# TEXT\_ISH13\_EA1N&2\_Session3\_12032021

Thank you very much, Mrs. Jones. We're on to agenda item three, which is local freight strategy, construction and operation. Under this item, we'll get a bit more local than we were previously and hear from the applicants and Suffolk County Council and other interested parties on

MARLESFORD MITIGATION SCHEME (A12)
PRELIMINARY DESIGN
(SHEET 1 OF 2)

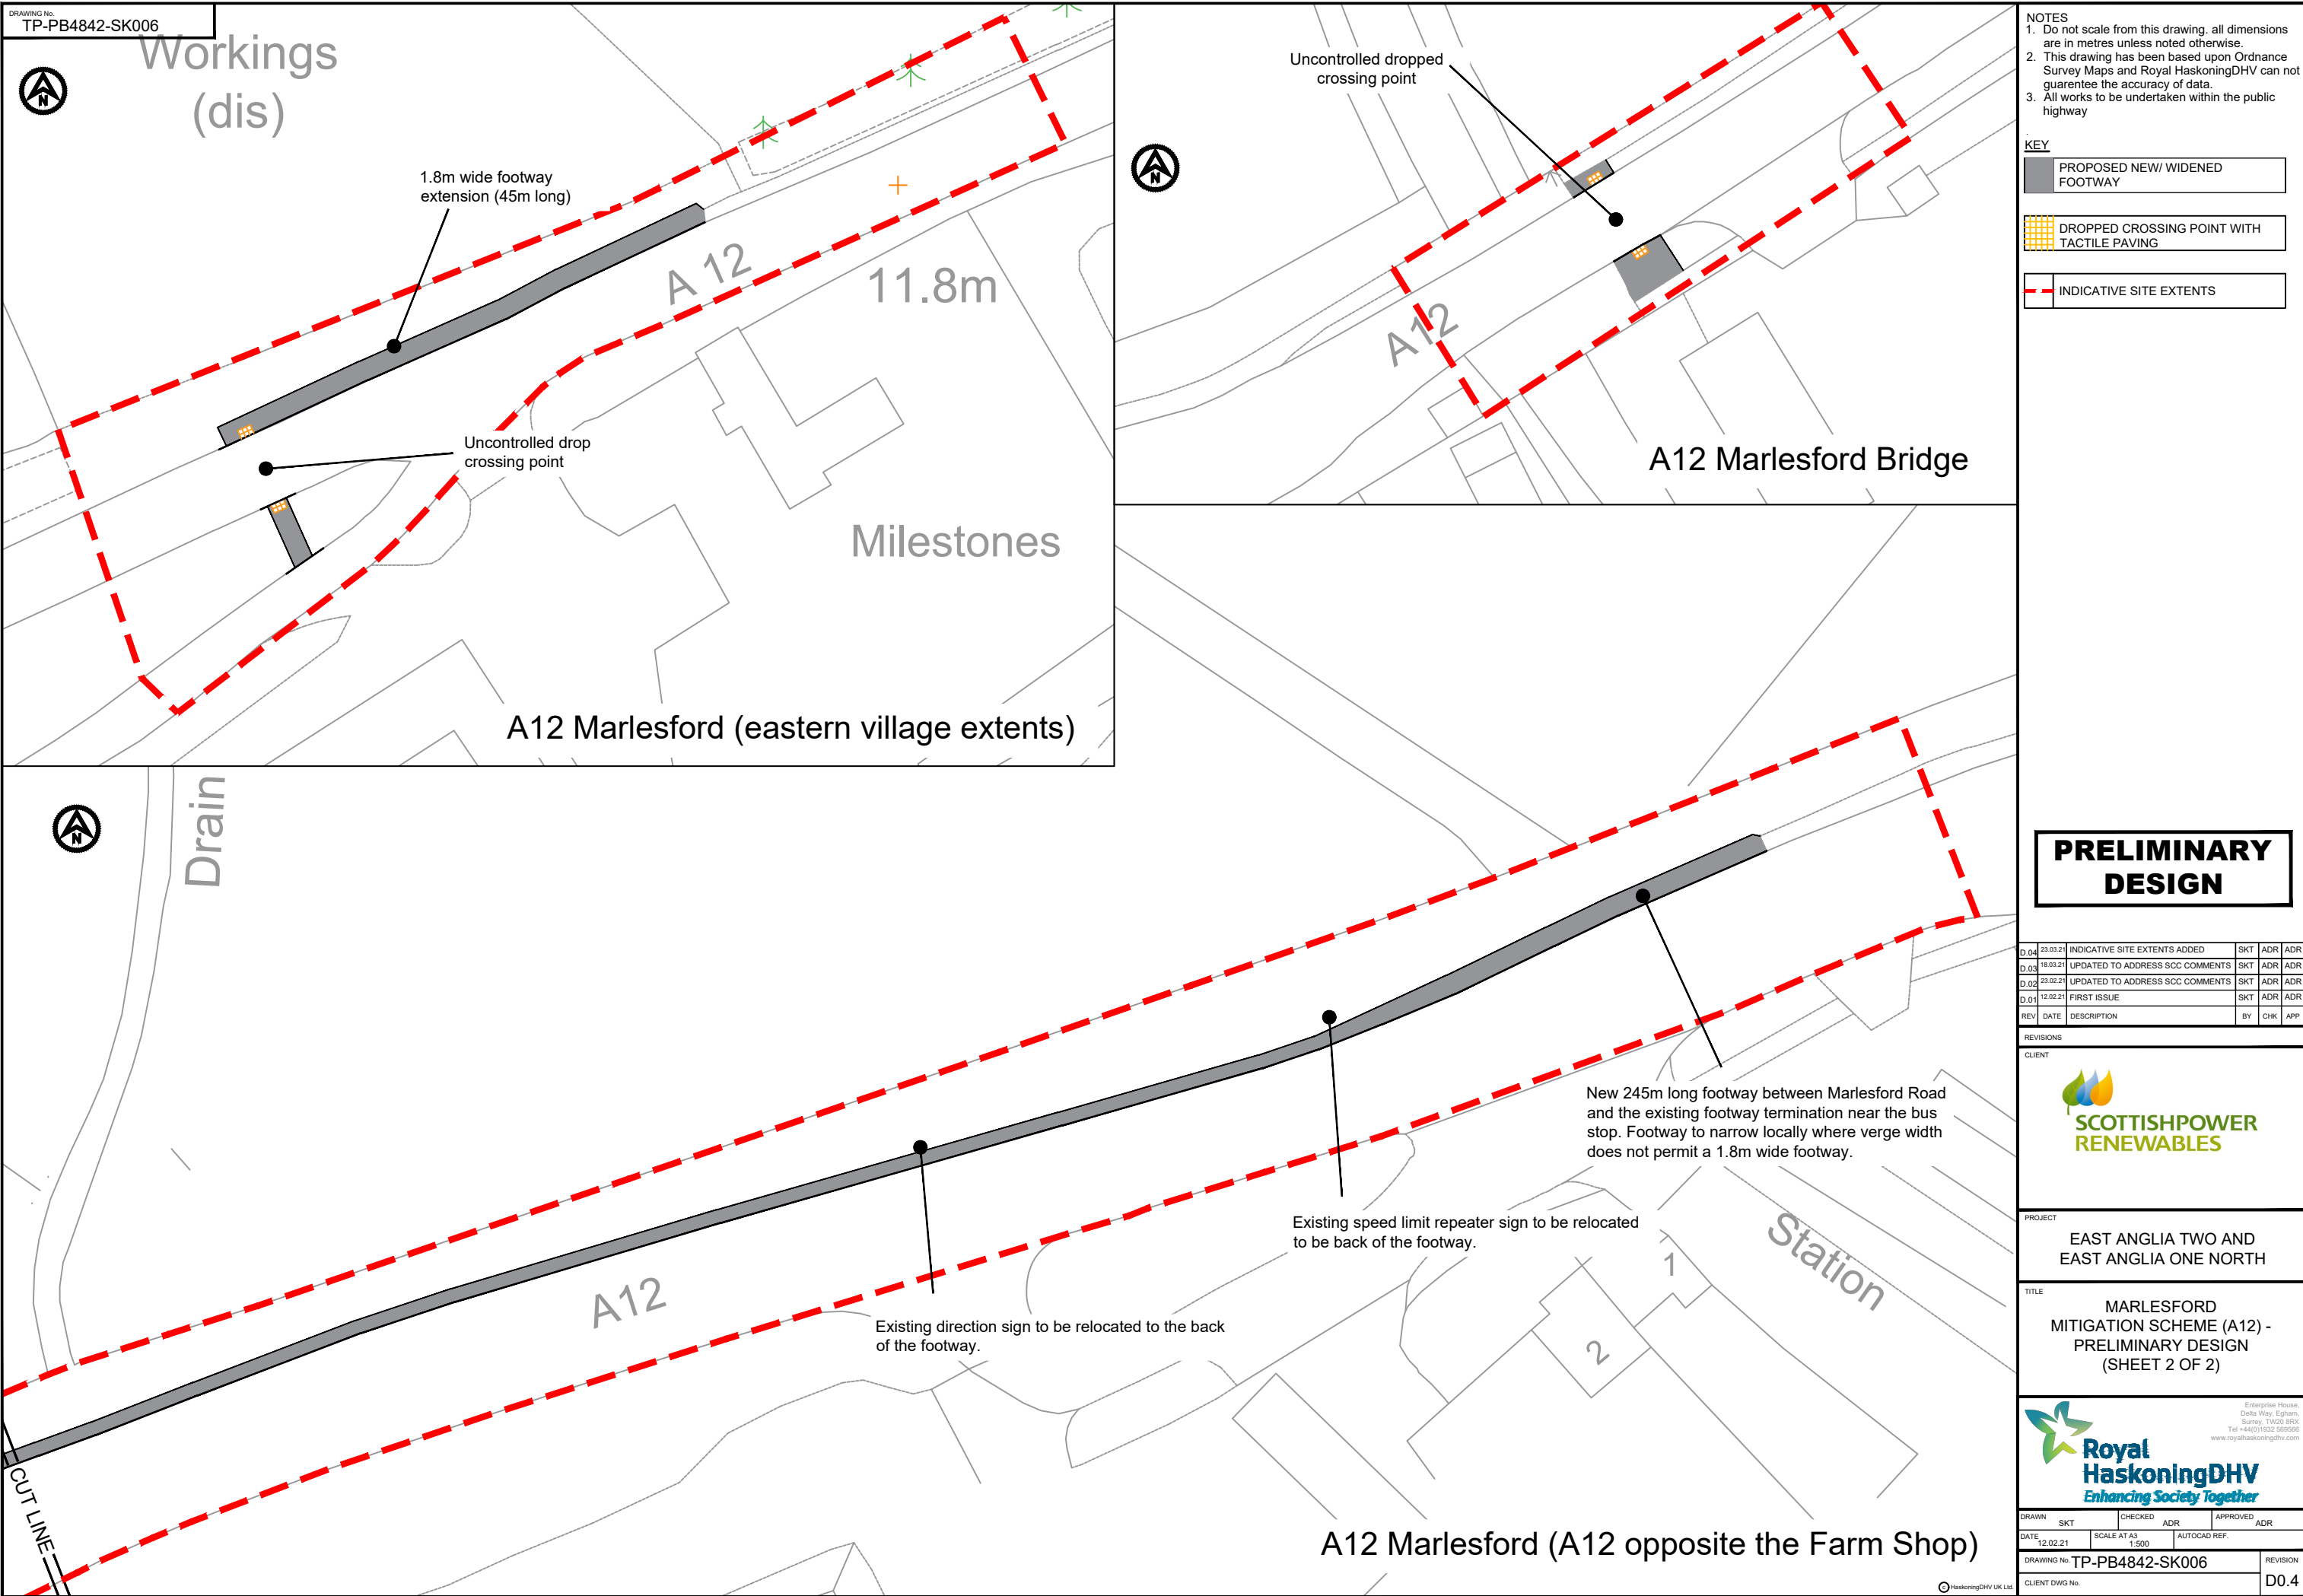
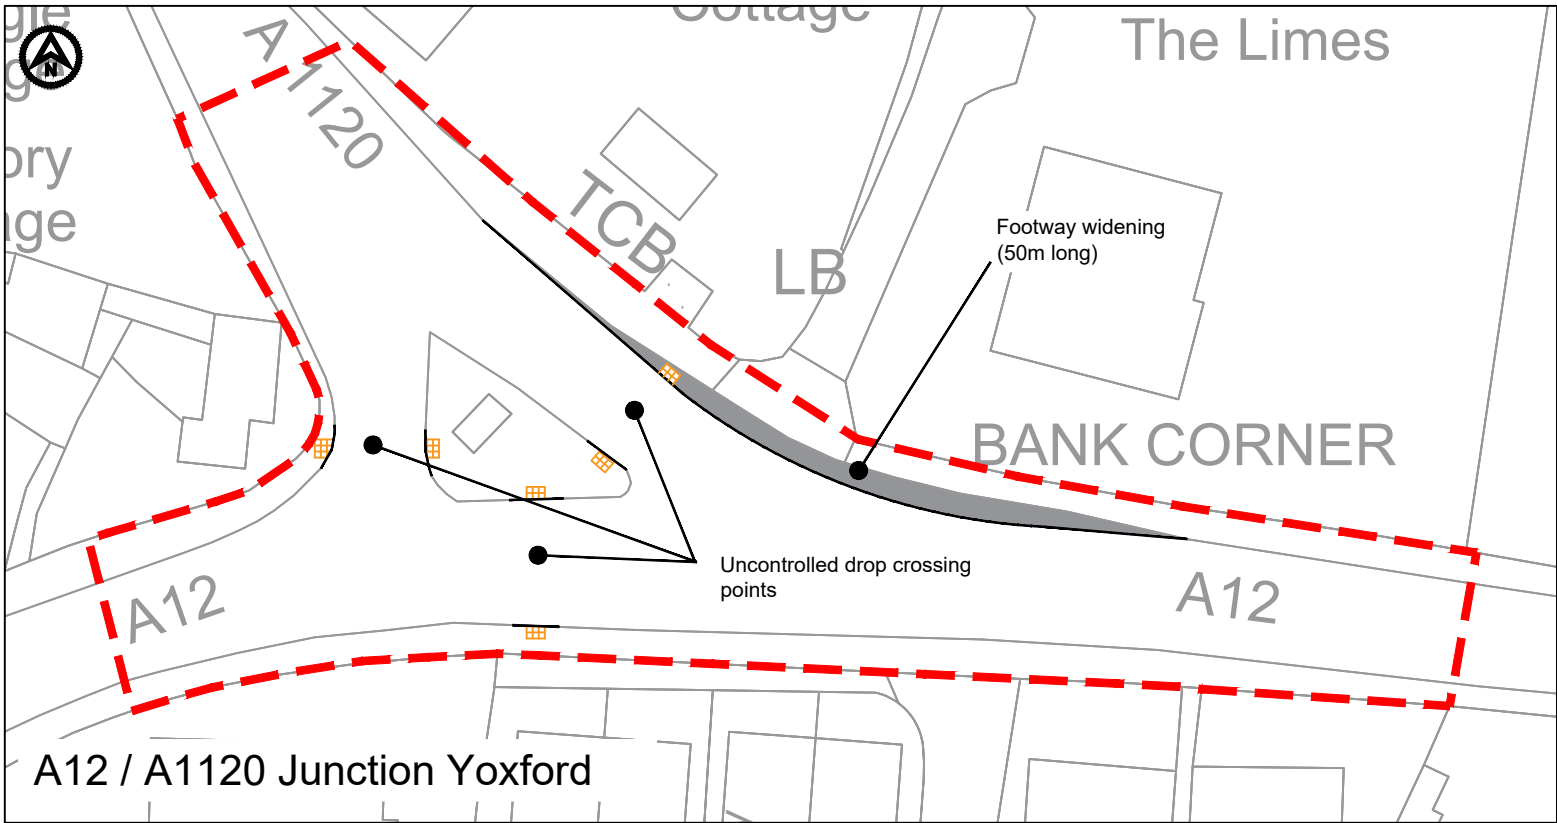
the the binary impact as it is so well put by Mr. Ross of the good process. And I would say the the applicant has worked with us and we have tried to actually focus on the impacts. And I think well not think I know we've we've got as far as we're concerned to the final stage where we have agreed the impacts and mitigation, notwithstanding that we still have reservations about the methodology. But I think it's important to actually get to the end point rather than worry about that. In terms of miles Feds. Yes, there's some footway works proposed. There's two sections one to the northeast, which is a little Glen amant. And one further to the south, which West, which is closer to wicker market, the furthest one, so the northeast part were brought in agreement with it, it is a it helps pedestrians cross the road, alleviate the anxiety, which was the main impact we're looking to have resolved. The issue of the South is just a bit of a thought process we're going through is the applicants proposed footpath on the south side. And we're just assessing that to see if that is the best solution to the impact. By nature, we've got to

if it's on the north side of the a 12, it forms a link without crossing the a 12 between the main residence of malford and wicker market, whereas it's on if it's on the south side, it does actually tie in a set of cottages and some houses which form part of miles. So we're just going through a thought process with that. So we're hoping to resolve that deadline eight. So that's where we are. And also just note that the applicant also offered some footway, improvements at Oxford to also alleviate some impacts there that we considered.

addressed in formulating that is that the actual mitigation works, which would entail in order to carry out footway improvements. Some works in the carriageway, whether it's closing off parts of the carriageway, whatever, we would effectively want those works to be completed before that route was then available for the construction traffic and operational traffic itself. So in other words, if you if you left, as it were, the putting forward of these works to shortly before the applicant was expecting to have the construction traffic management plan approved, there might then not be sufficient time to enable the works to be completed for the footway mitigation works before then that becomes needed to be available for actual construction traffic. So it's really just a sequencing point, we don't think it's not capable of being resolved. But we just wanted to flag that up. And it might need some fine tuning of the wording of the outline, construction management plan just to recognise that there is that kind of as it were sequencing of timescales. So that's a sense of fine tuning point. But since it relates to malls, for instance, I say we want to end up with the mitigation in place before it's actually needed. We just thought we ought to raise that. Yes, thanks very much. That's very useful. So you're saying that we'll go into a revision of the ctmp, we would, we would suggest that's a sensible way of dealing with it. Obviously, it's for the applicants to work out how they want to take that point on board, but without a useful way of dealing with it. Thanks. So that would help narrow the issues there that reviews or so perhaps that's something that can go into whatever, Suffolk County Council and the applicants will put in a deadline age as an agreed position. And what would also be helpful is if you can say what's agreed and also what's not agreed. So it's almost like a statement along common ground if you like, if there's anything that's outstanding, that will be very useful as well. Thank you very much indeed.

mitigation in the form of wind improvements as a proportionate response to the cumulative impact, and these are, these are the details in the the outline for an outline has given them in the outline, construction traffic management plan Rep. 609.

were pretty much agreed on the principles and the concept of this mitigation. But there's some finer detail. And I say fine. Now, obviously, we're still at concept stage. But there's a bit of detail to to agree with Suffolk County Council and we're hoping to to wrap that up
